LIME DOWN SOLAR PROJECT

**DEADLINE 2 COMMENTS
STOP LIME DOWN**

22 May 2026

Coordinate system: British National Grid
Scale: 1:10,000 @ A3

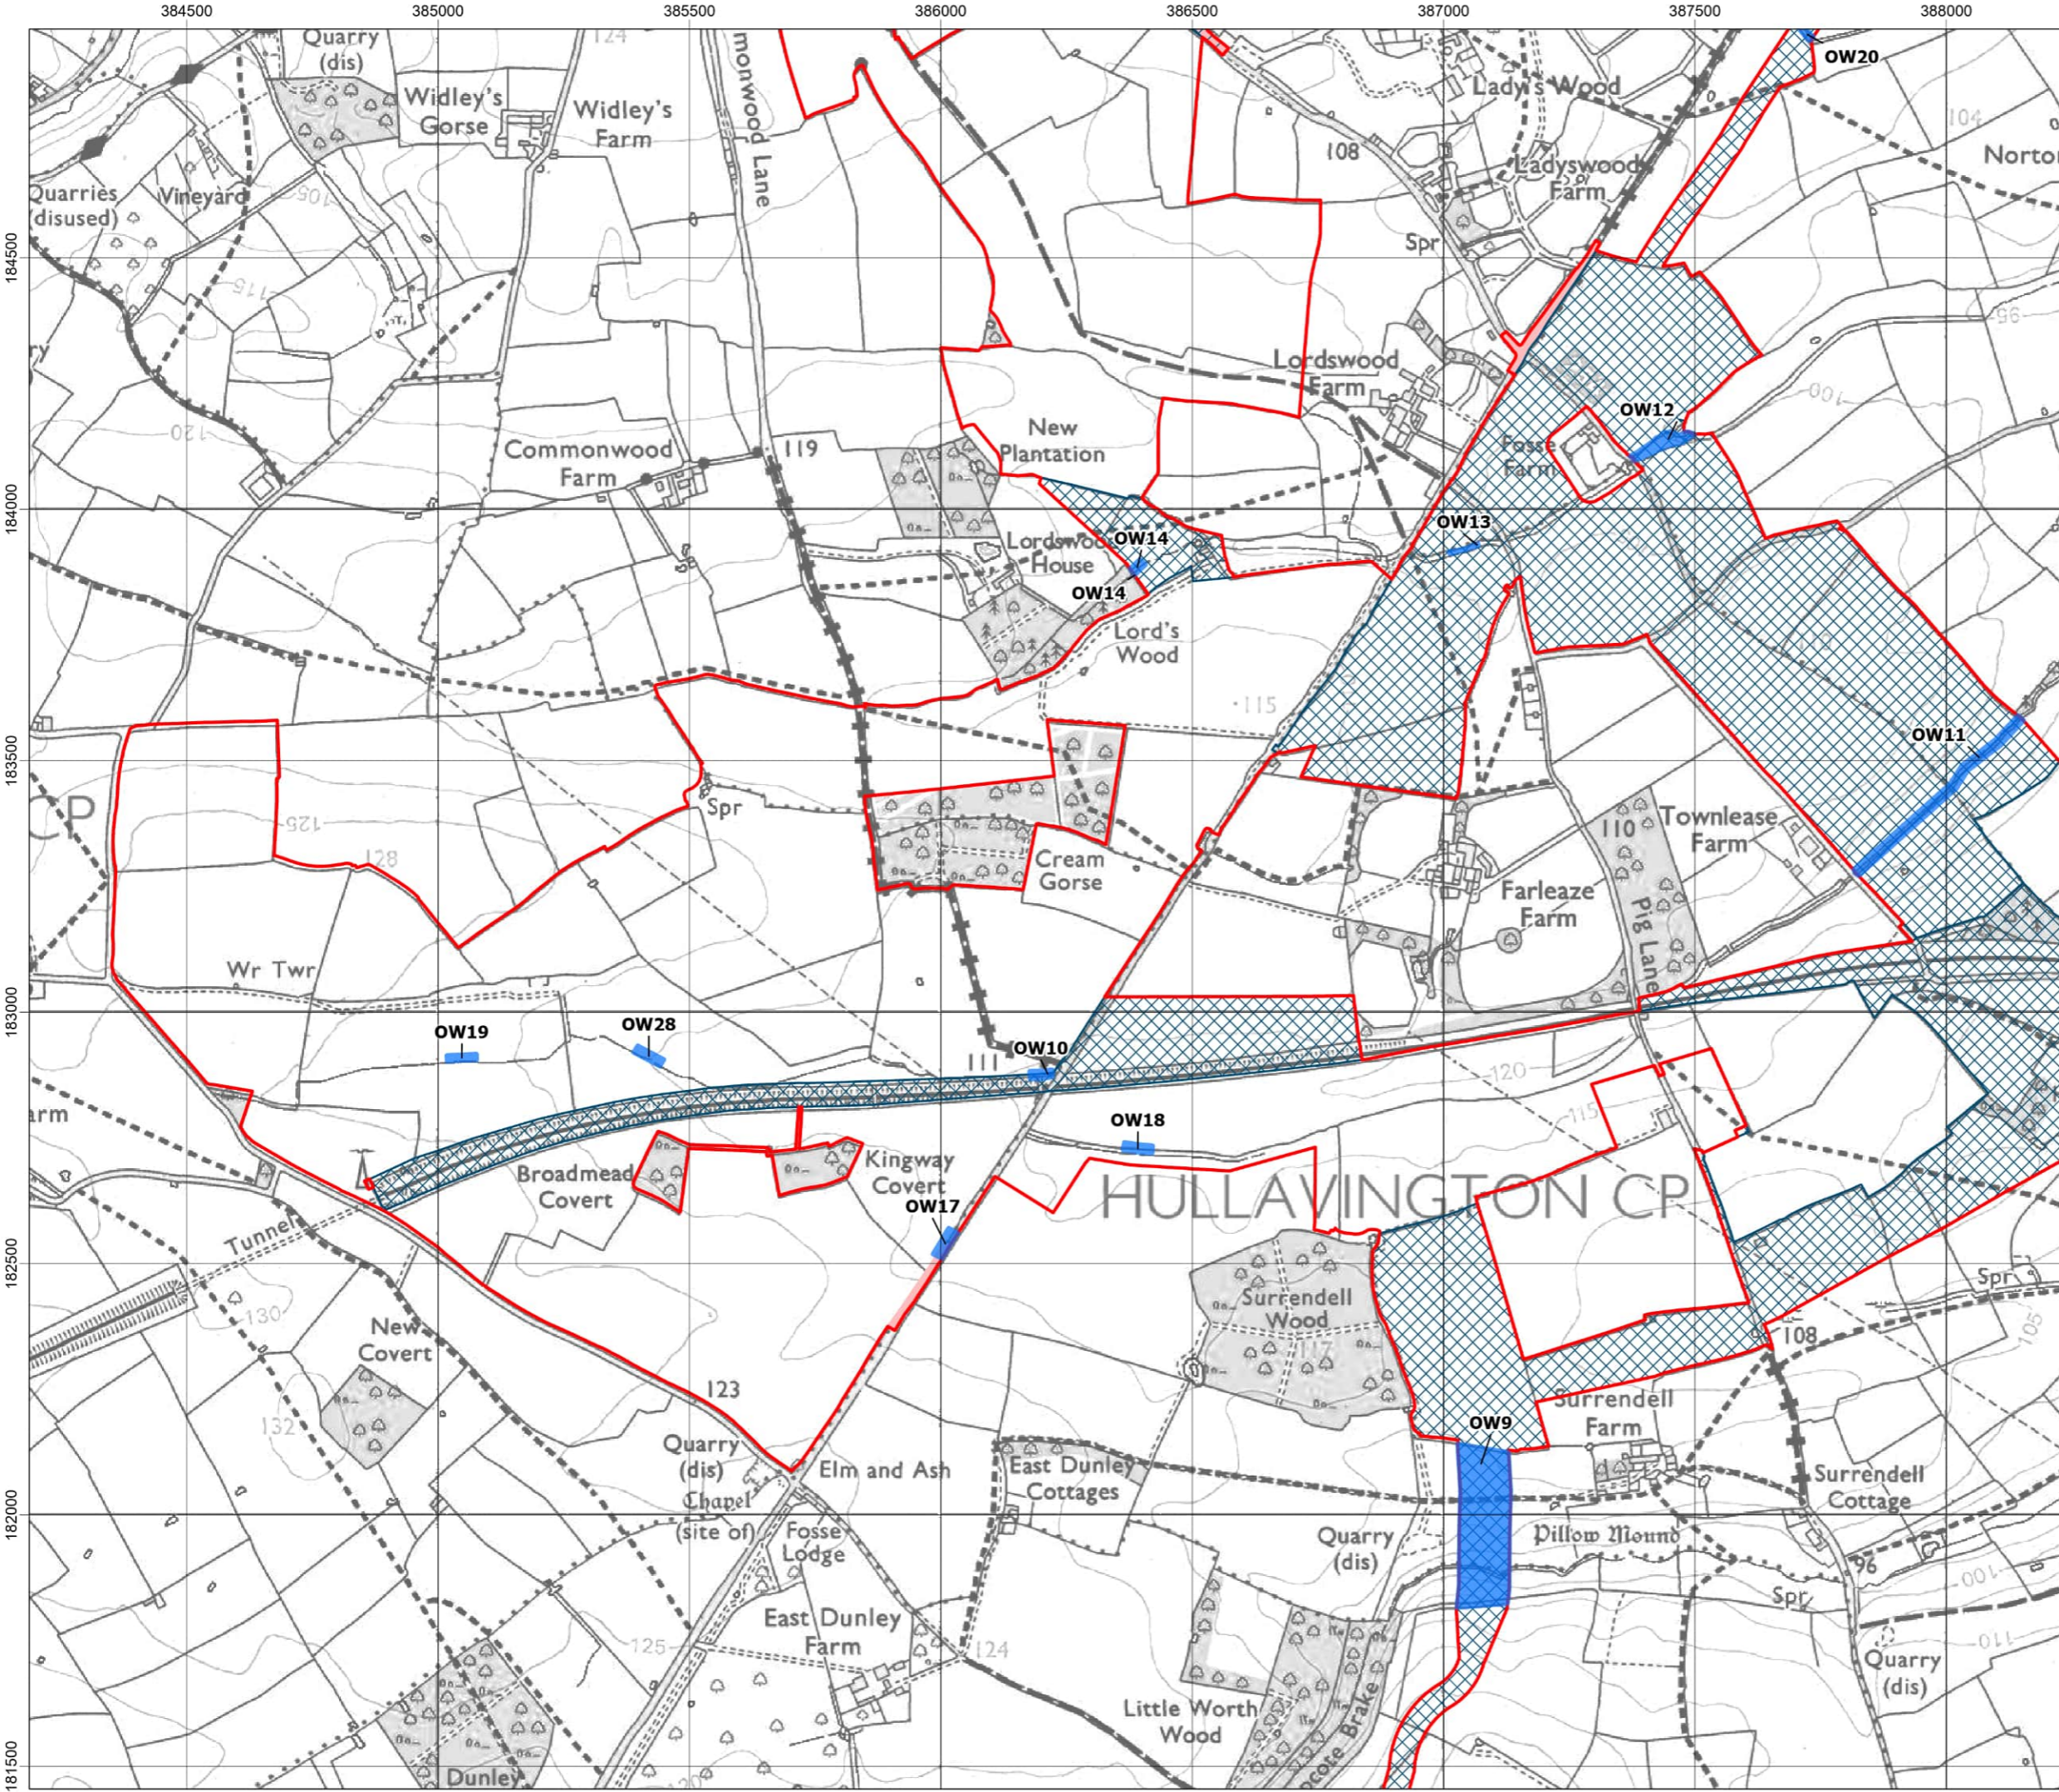
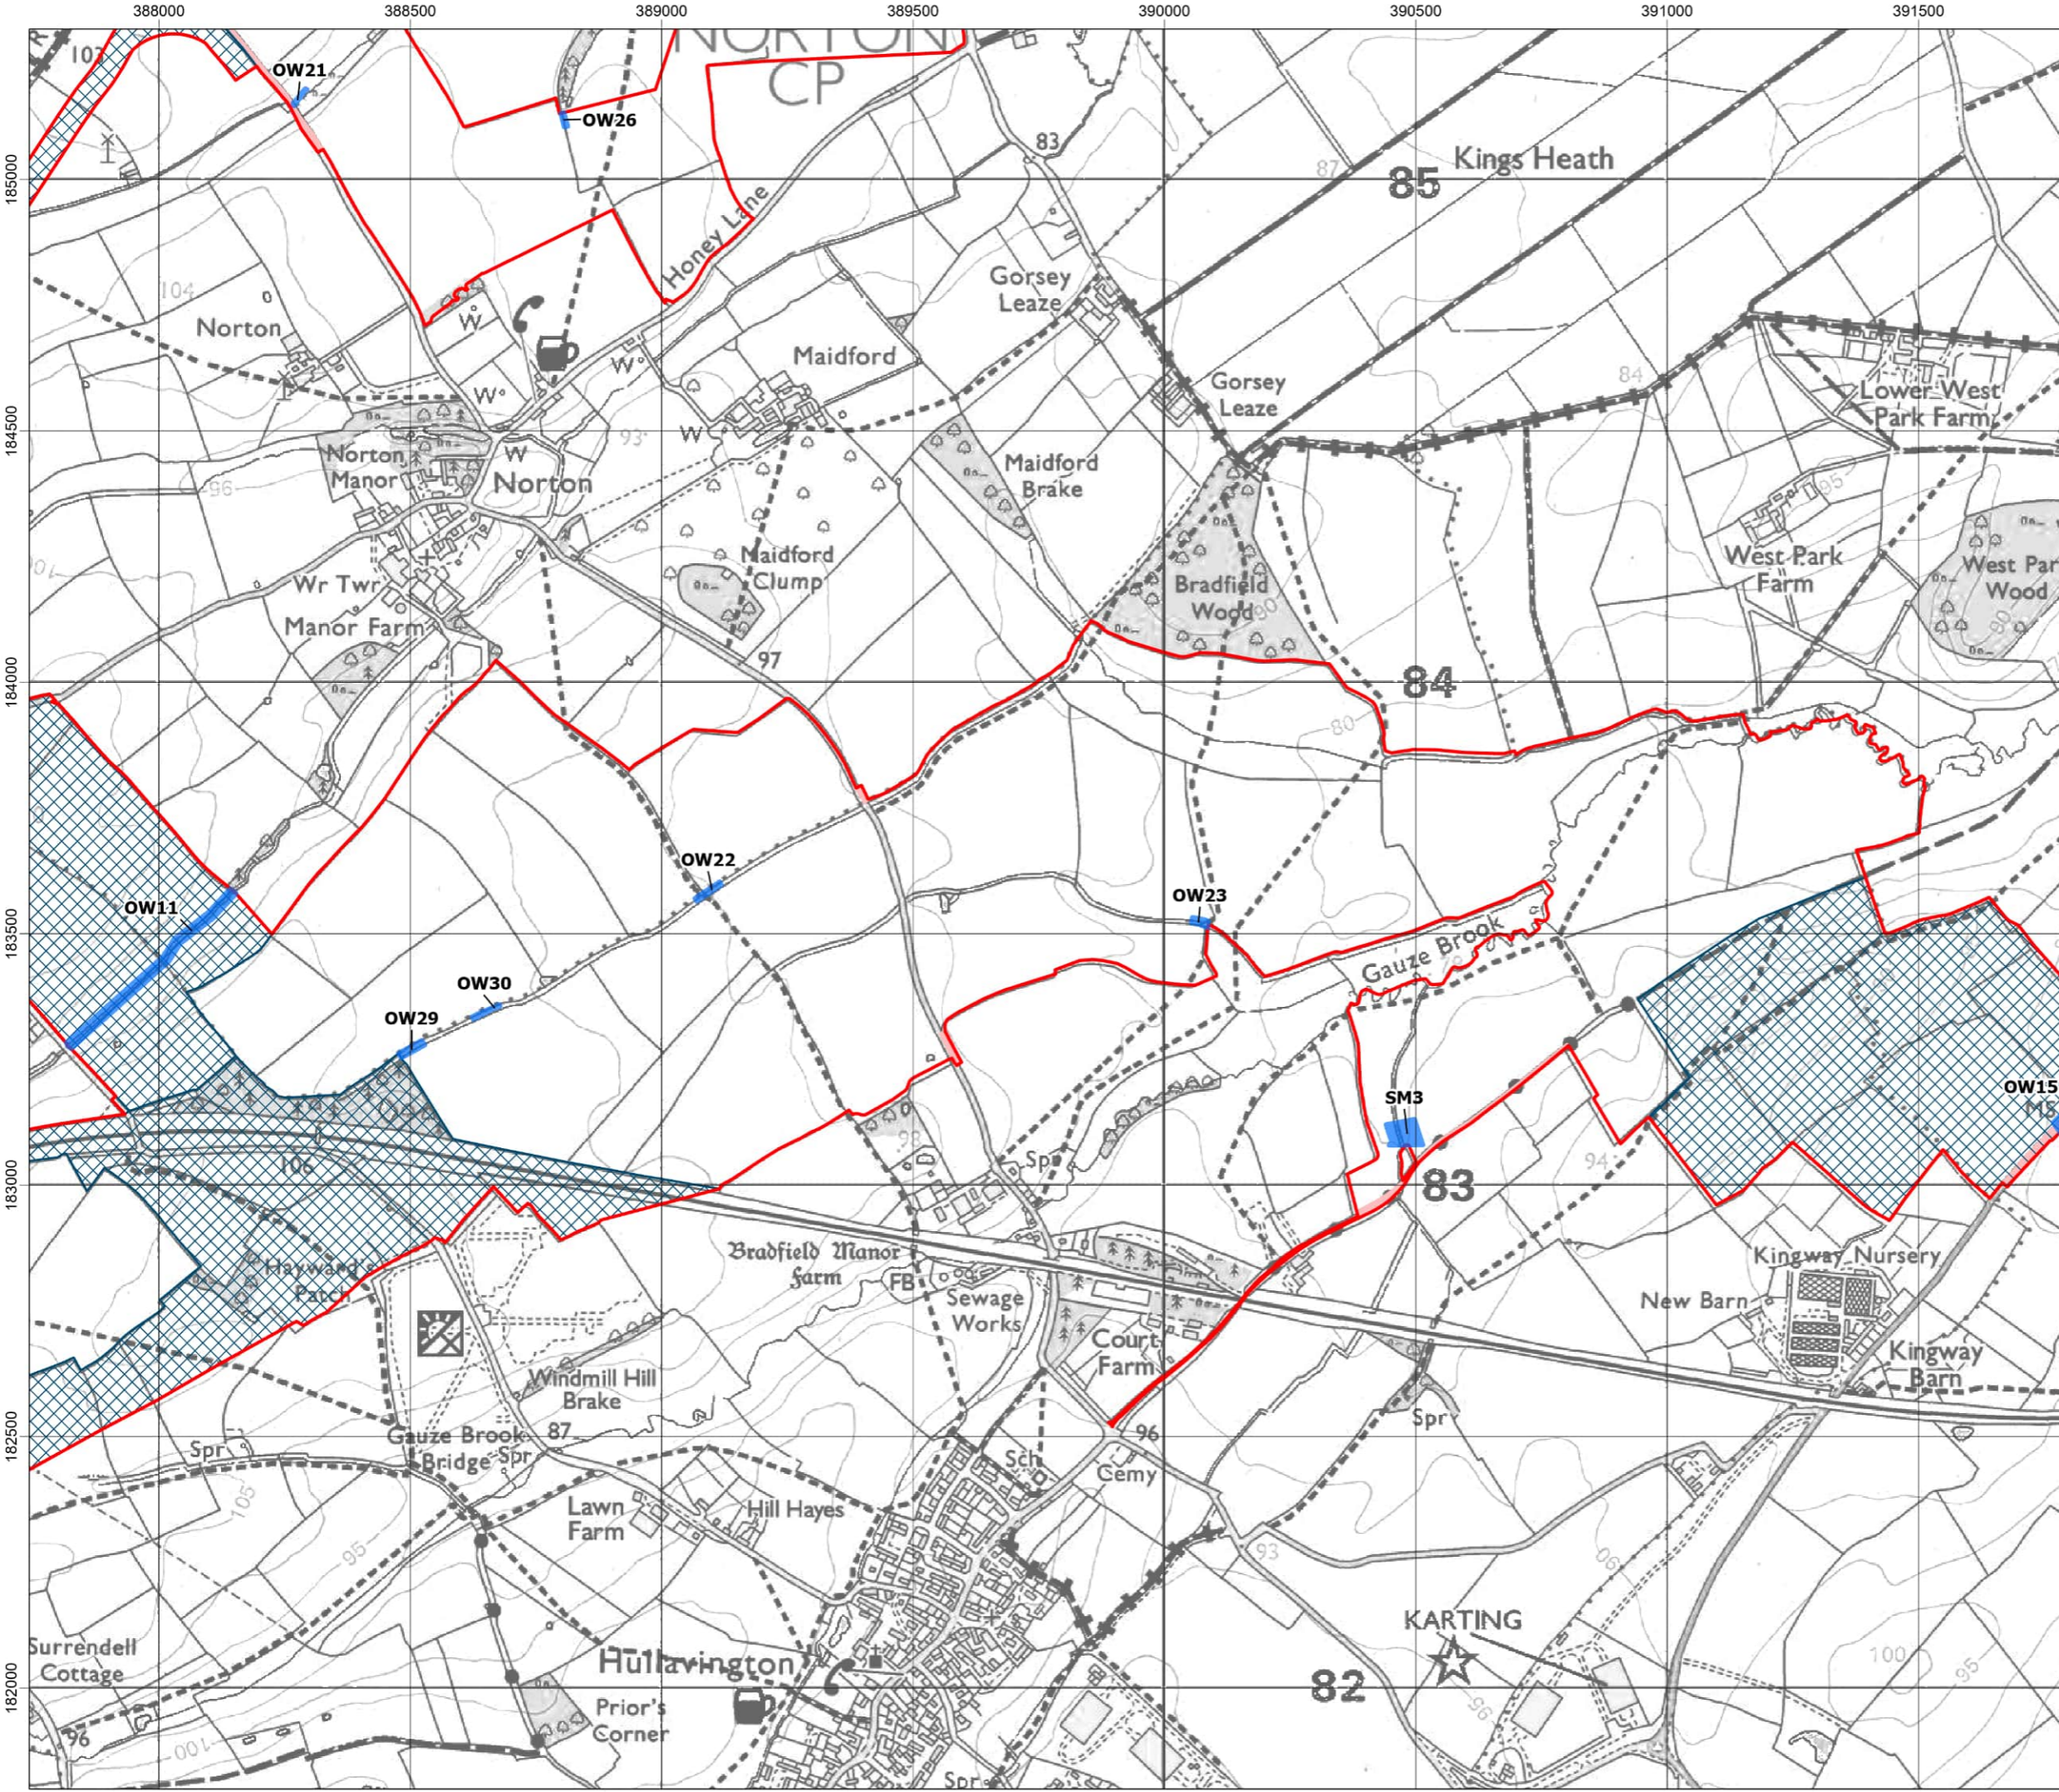
- 2.6.2.1. Minimal changes have been made to the site-specific FRAs and covering report;
- 2.6.2.2. The Firewater Containment Report does not address the credible worst-case scenario of a BESS fire taking more than 4 hours to extinguish;
- 2.6.2.3. It is unclear whether the Watercourse Crossing Schedule is exhaustive and the Schedule would benefit from an accompanying map; and
- 2.6.2.4. The Water Framework Directive Assessment is lacking in necessary detail.
